**Our Case Number:** ABP-318704-23

**Re:** 10 year development of 9 Wind Turbines and associated infrastructure  
at Borrisbeg and adjacent townlands, near Templemore town in Co. Tipperary  
(<https://borrisbegplanning.com>)

**Re. Strategic Infrastructure Development – 10 year development of 9 Wind Turbines and associated infrastructure at Borrisbeg and adjacent townlands, near Templemore town in Co. Tipperary**

**ABP Case ref. PA92.318704**

PROJECT No.:	DRAWING No.:	SCALE:
220310	220310 - 04	1:5,000 @ A1
DRAWN BY:	CHECKED BY:	DATE:
GO	KD	16.11.2023
OS SHEET No.:	REVISION.:	
4341, 4342, 4399, 4400, 4457, 4458	P01

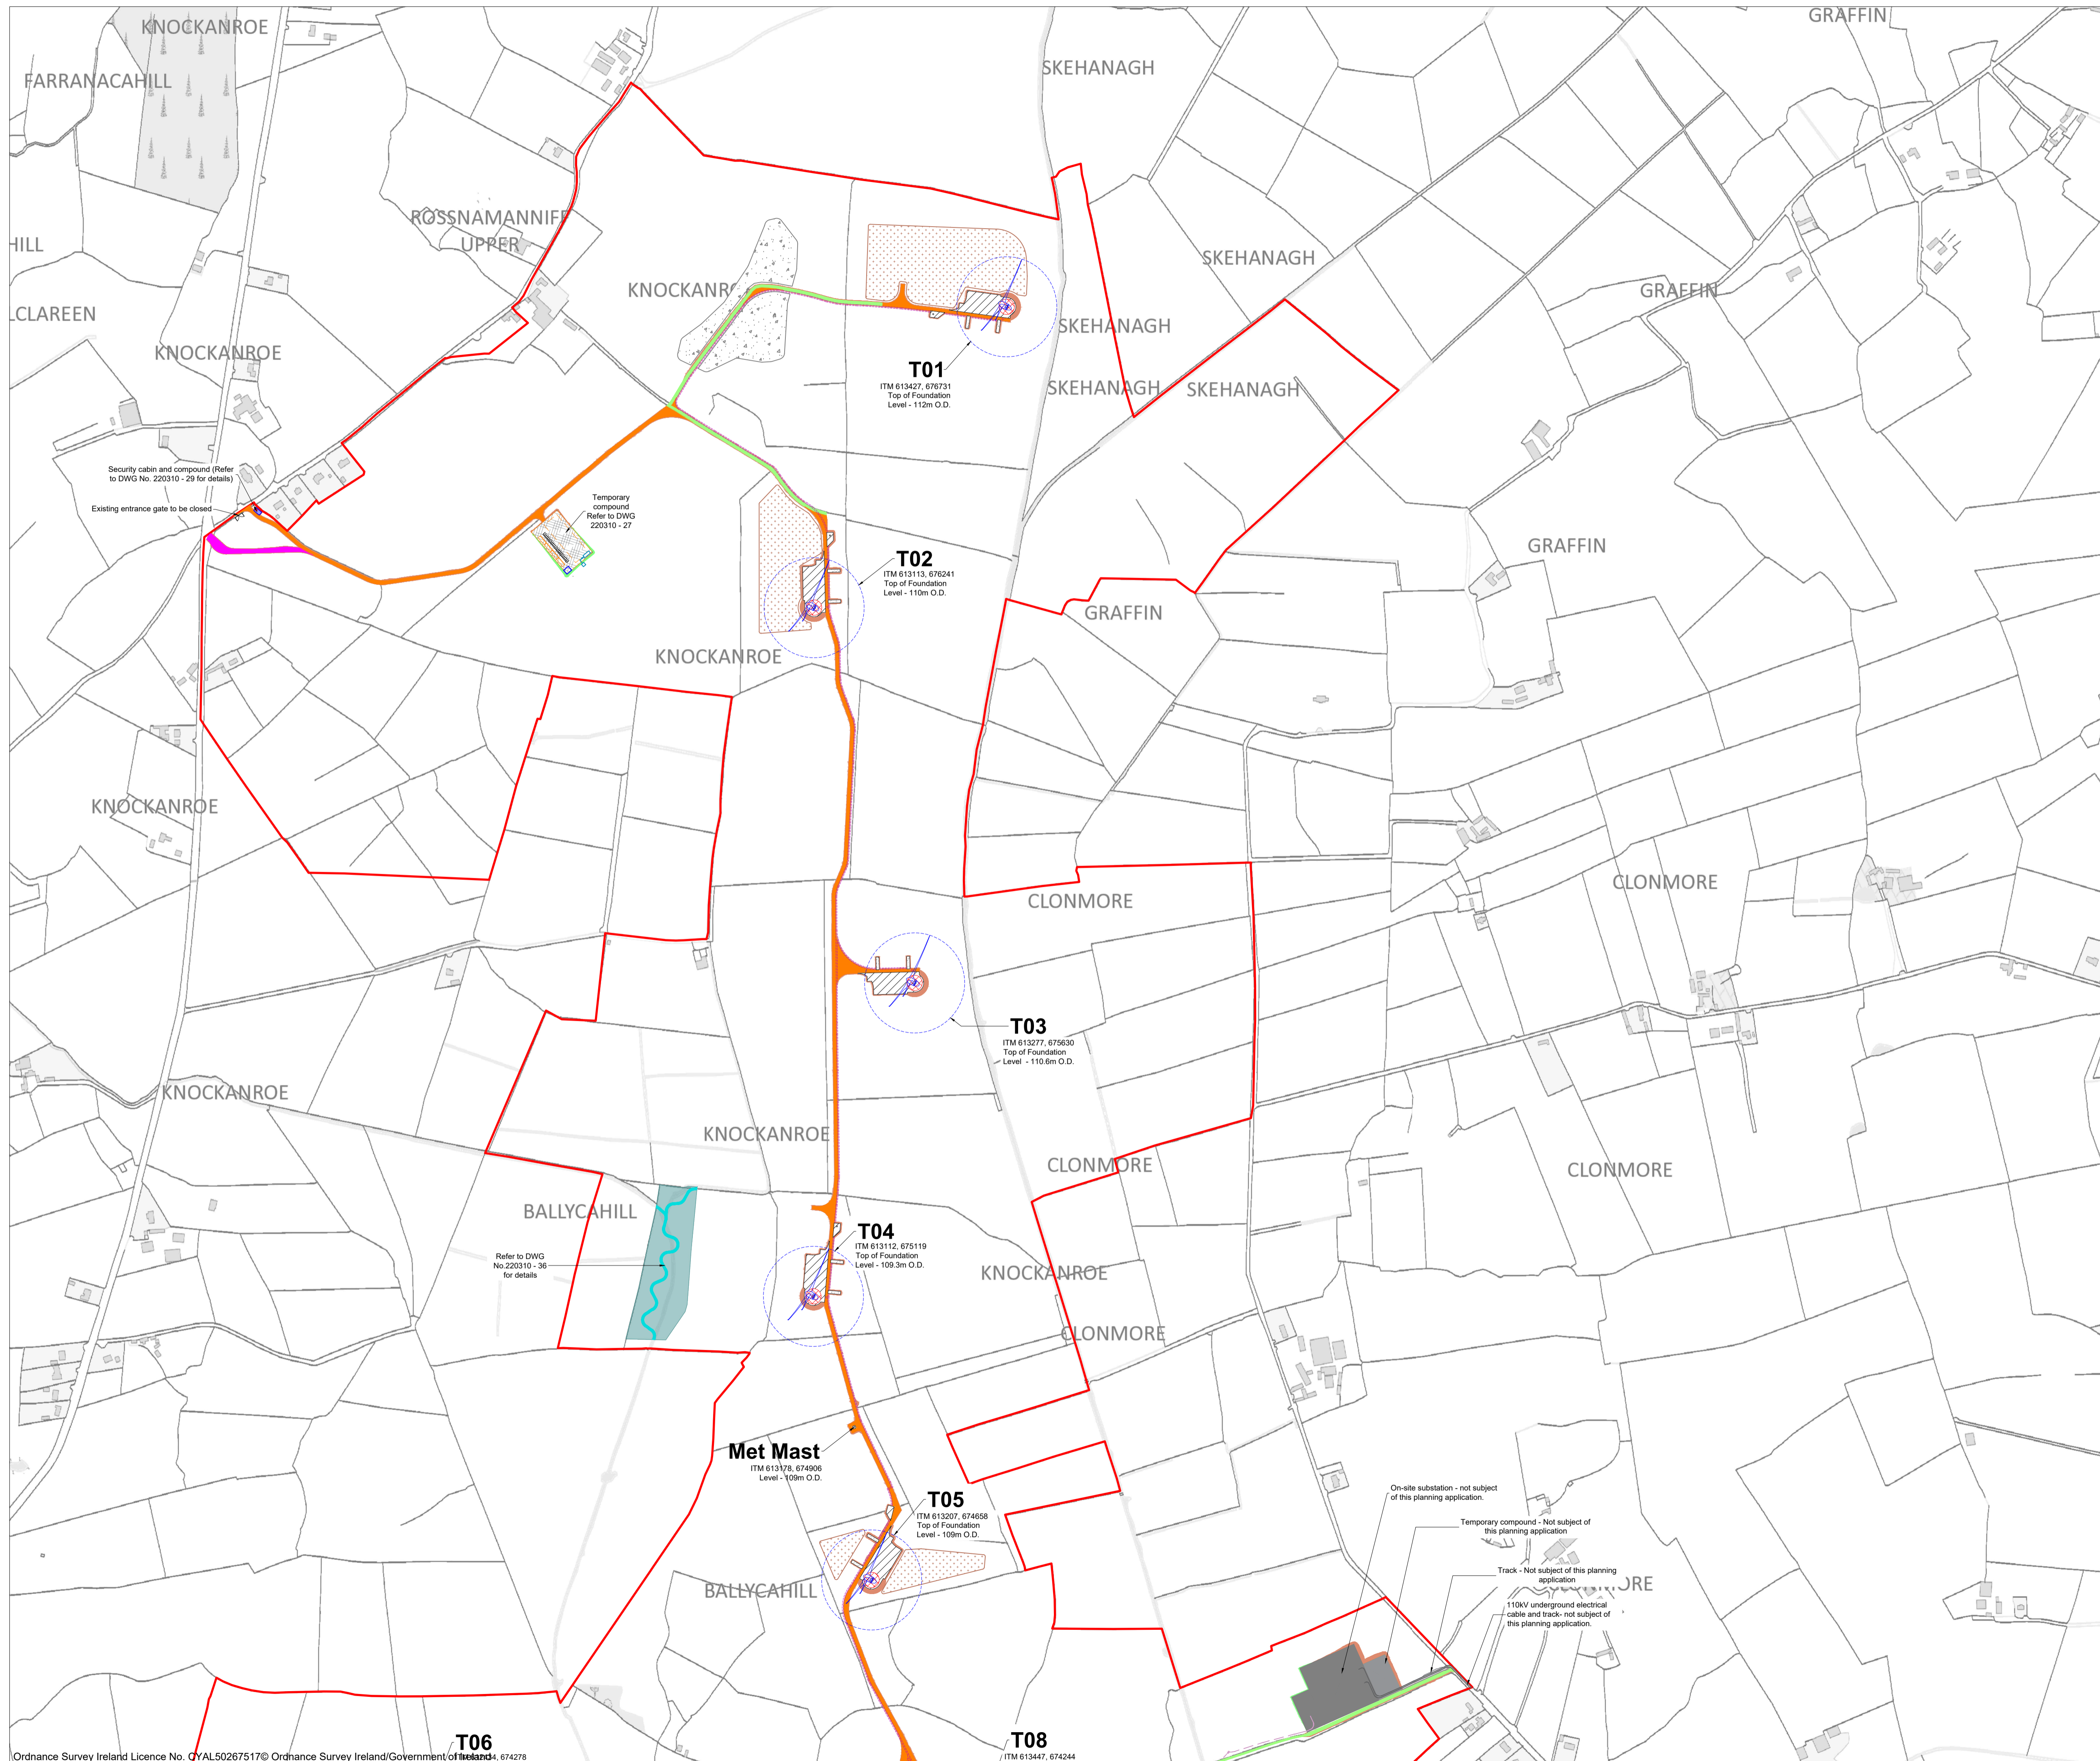
In that regard, it is noted that the subject application description included in Section 4.1 of the EIAR includes reference to junction accommodation works and a new temporary access road off the L3248 to facilitate turbine delivery to the site. The location of the proposed temporary access to facilitate access for abnormally sized loads is detailed on, among other drawings, drawing no. 220310-04 and drawing number 220310 – 37.

Notwithstanding the development description included in Section 4.1 of the EIAR describing junction accommodation works and a new temporary access road off the L3248, to facilitate turbine delivery to the site, it appears from a review of the application and accompanying drawings that the temporary access is proposed at the junction of the N62/L3248. It is unclear that the proposal does not represent a new access, although temporary in nature, to the N62, national road, and as such, has the potential to directly conflict with the foregoing provisions of official policy.

In addition to the foregoing, based on the information provided in the subject application, it does not appear that the proposed temporary access for abnormally sized loads proposed at the junction of the N62/L3248 adheres to design standards included in TII Publications.

Design Standards addressing '*Geometric Design of Junctions (priority junctions, direct accesses, roundabouts, grade separated and compact grade separated junctions)*' are set out in TII Publications DN-GEO-03060. Although it is noted that Section 15.2.1.4 of the EIAR makes reference to TII Publications DN-GEO-03060 Design Standard, the proposed temporary access for abnormally sized loads proposed at the junction of the N62/L3248 does not appear to conform to the design standards set out in TII Publications DN-GEO-03060 and may represent a departure from standard.

TII has no record of a '*Design Report*' being prepared or submitted in relation to the proposed temporary access for abnormally sized loads proposed at the junction of the N62/L3248 and this is considered a significant oversight having regard to the nature of the development proposed and TII considers that this issue requires resolution to ensure safe and appropriate access is provided that safeguards the safety of all road users on the national road.
